# **Lime Down**

Solar Park

## **Change Application and Consultation Report (Change Application)**

**June 2026**

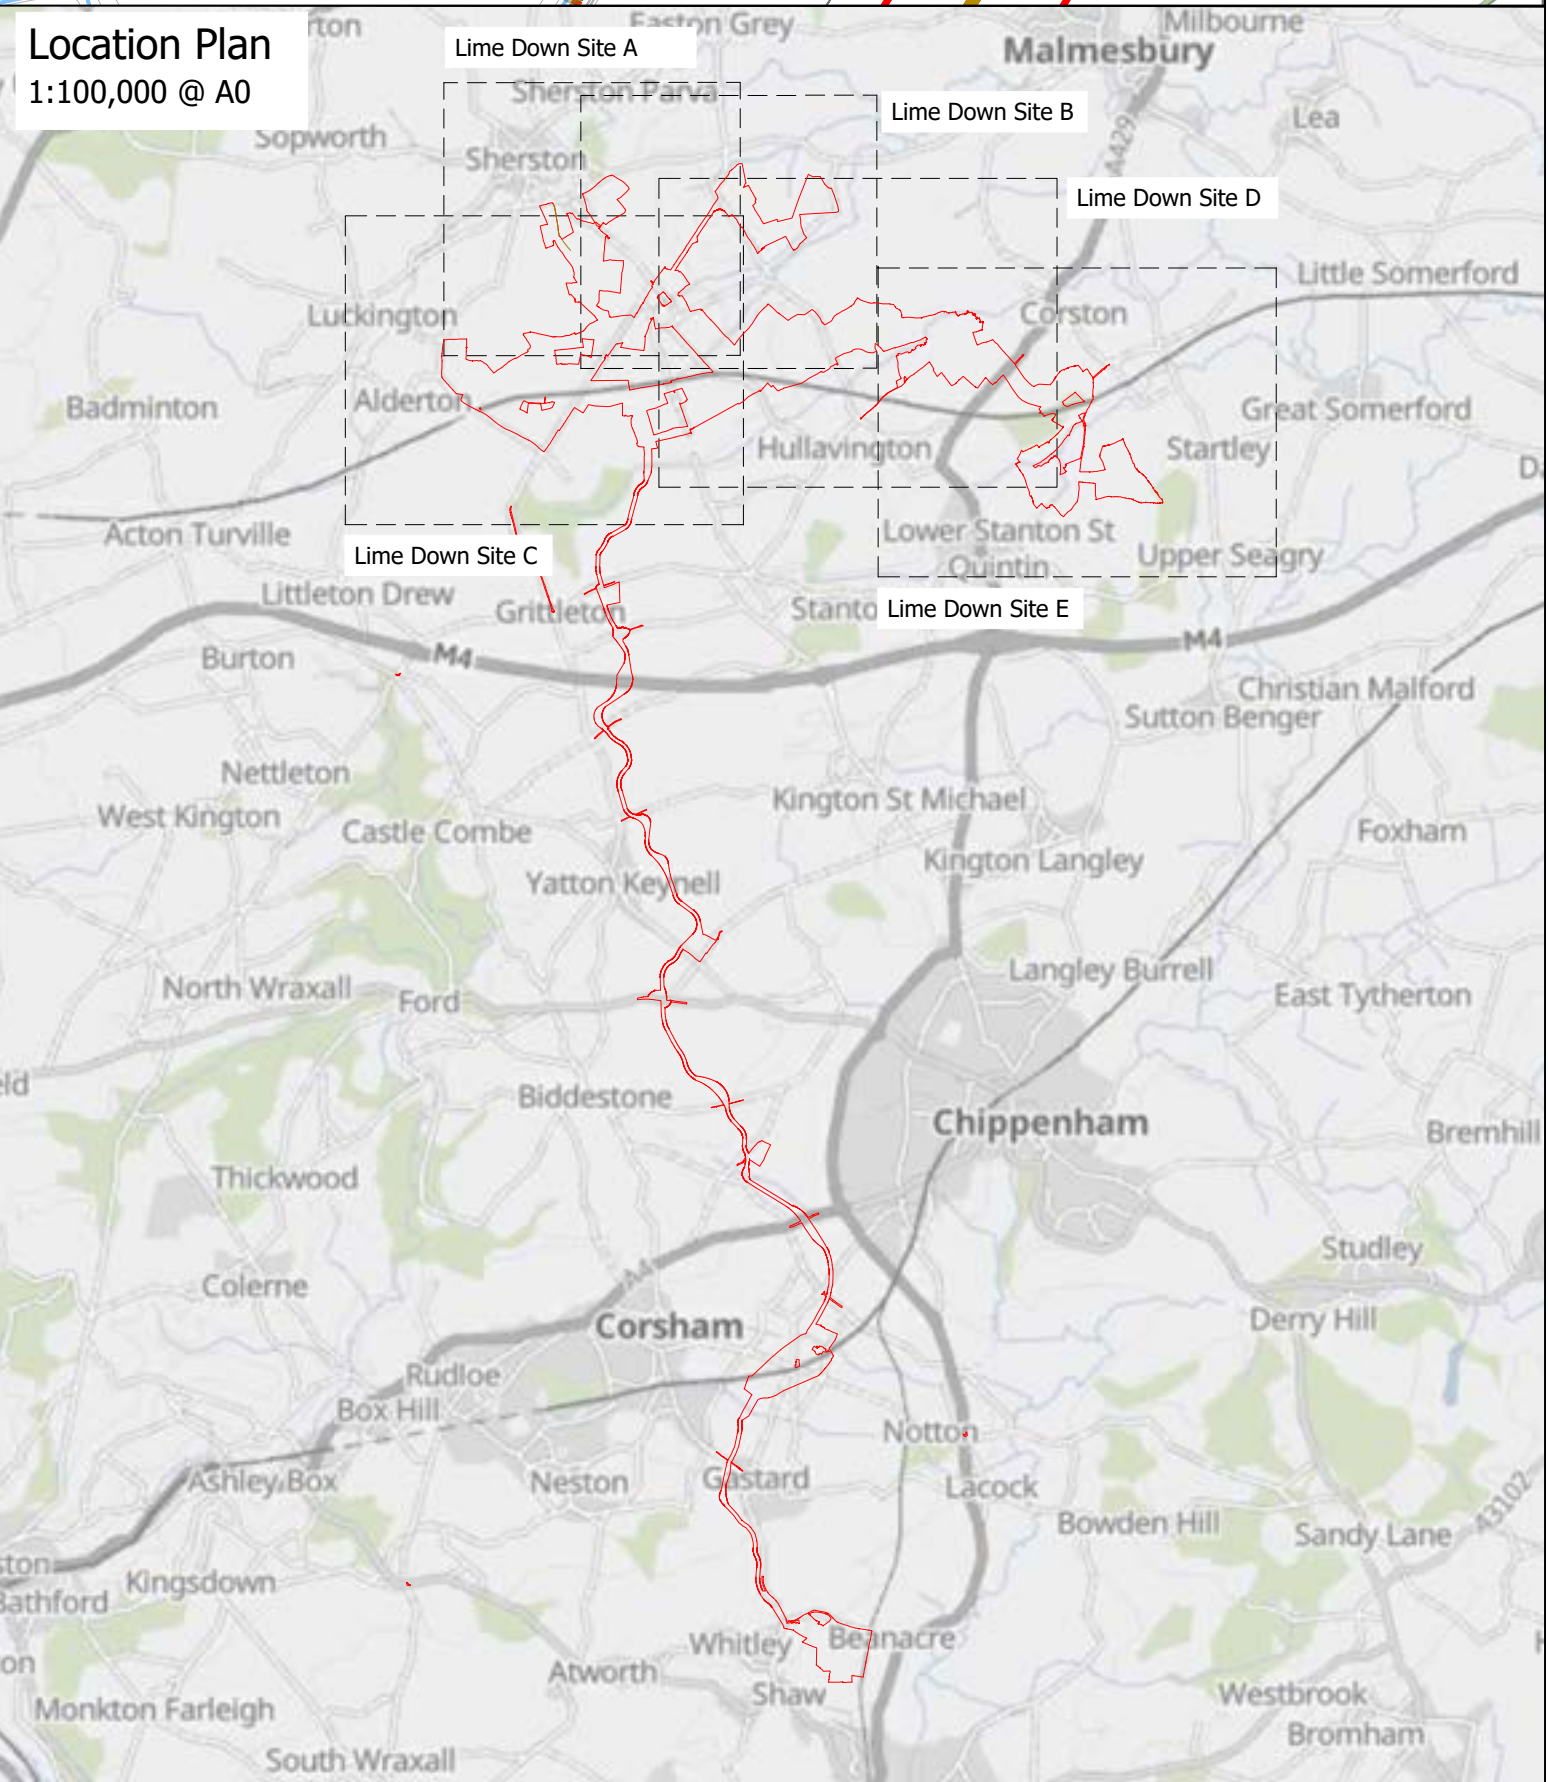
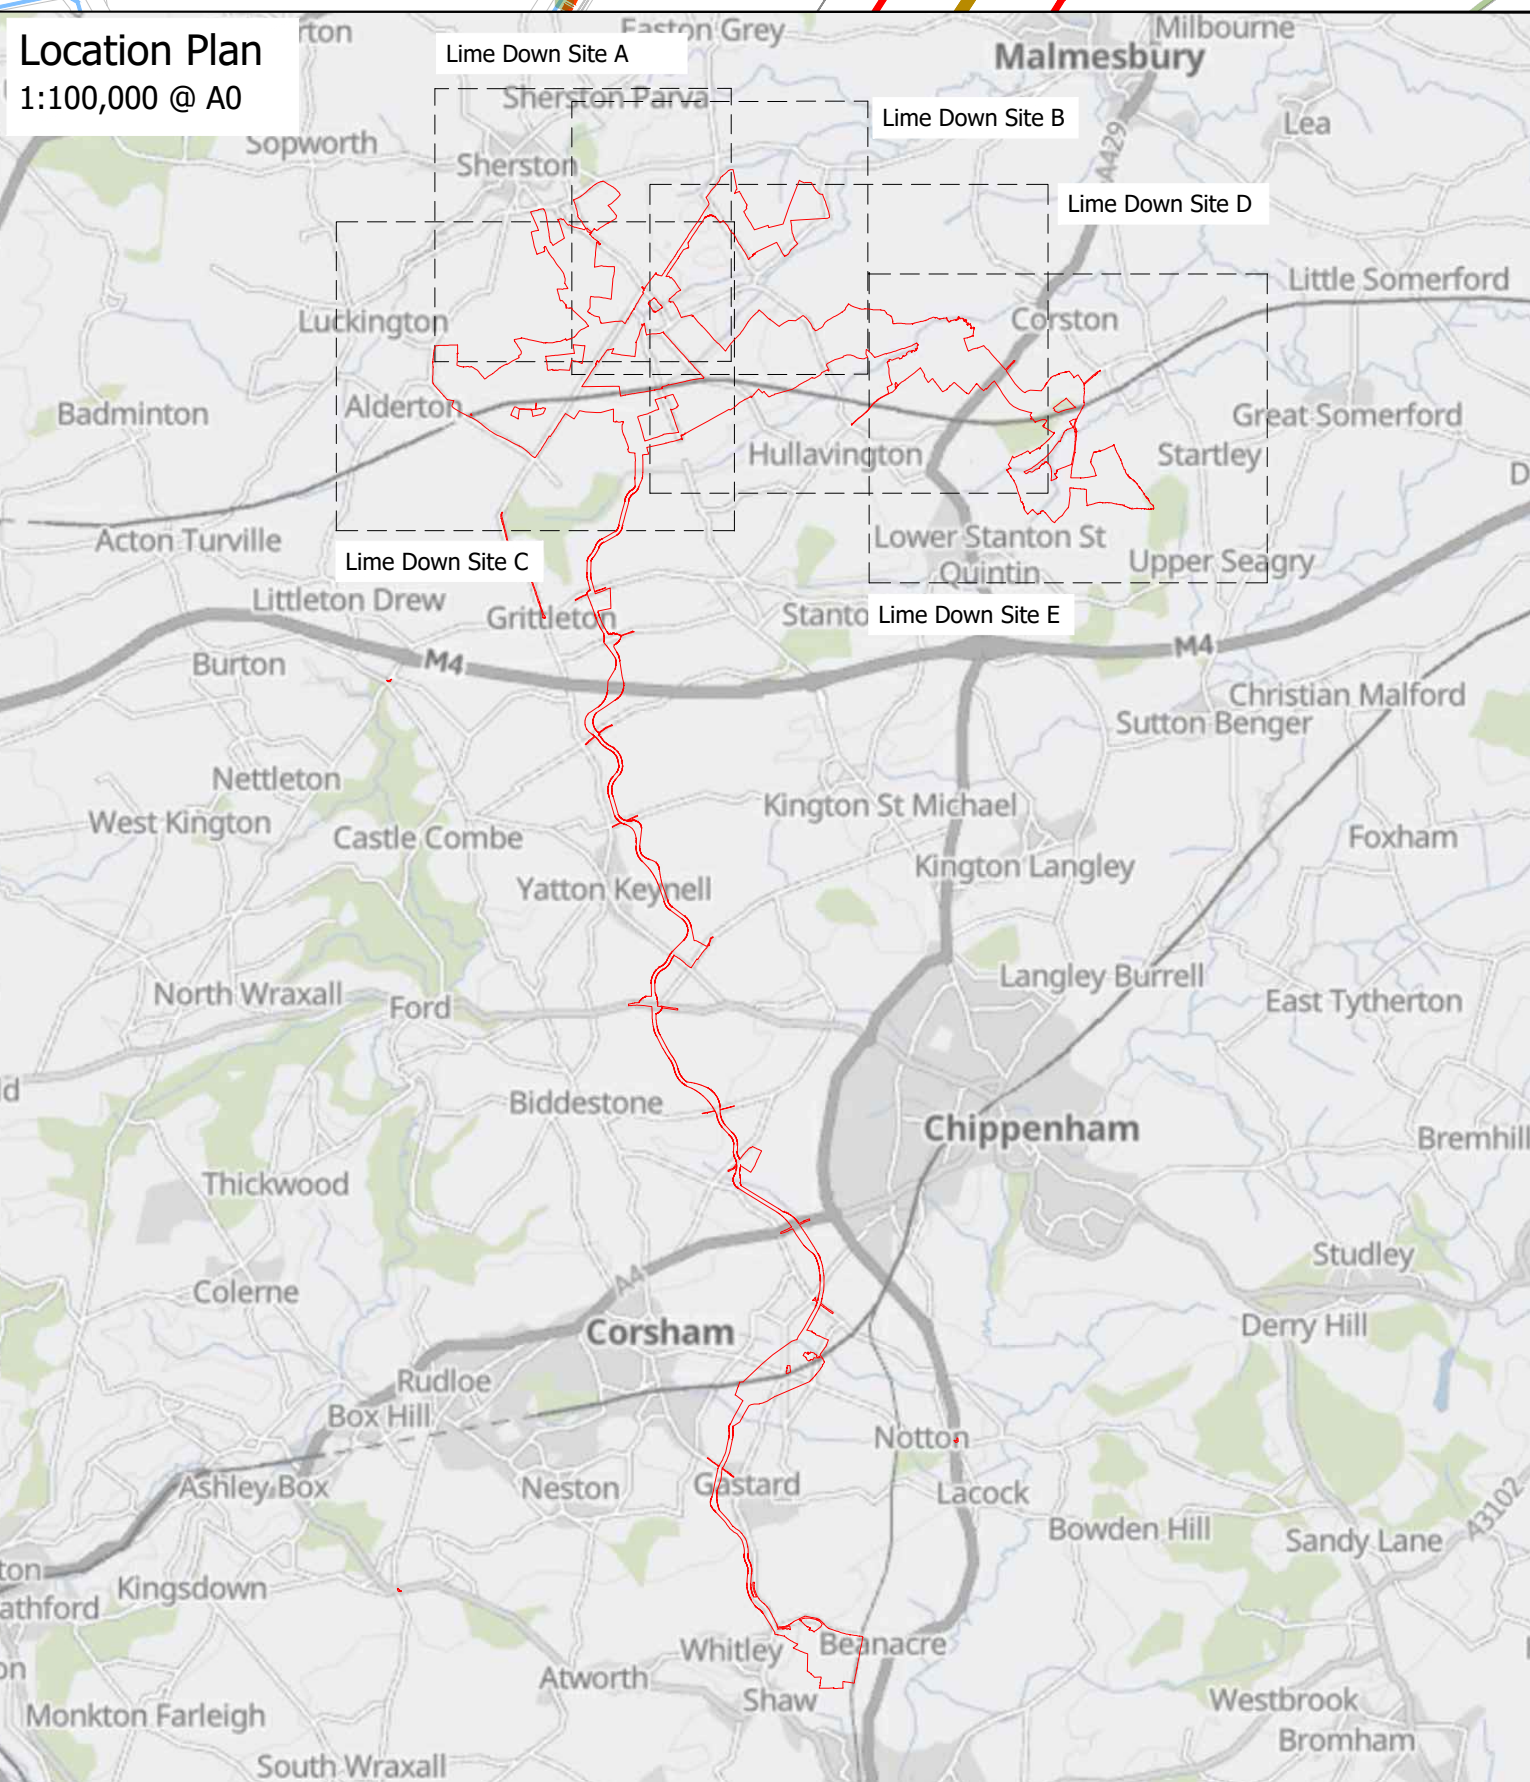
- 3.1.14 Change 4 comprises the removal of Solar PV Infrastructure from Field C9 to reflect ongoing engagement with the CNL Board related to the potential significant adverse visual effects for receptors located on Alderton Road. The removal of the Solar PV Infrastructure in this location results in a reduction in significant effects for Alderton Road.

- 3.1.3 The removal of the Solar PV Infrastructure in this location results in a reduction in significant effects for Alderton Road.
- 3.1.4 The **Works Plan [EN010168/APP/2.3] [Change Application]** and Parts 1-4 of the **ES Volume 2, Figure 3-4 Landscape and Ecology Mitigation Plan [EN010168/APP/6.2] [Change Application]** have been updated to reflect Change 4.
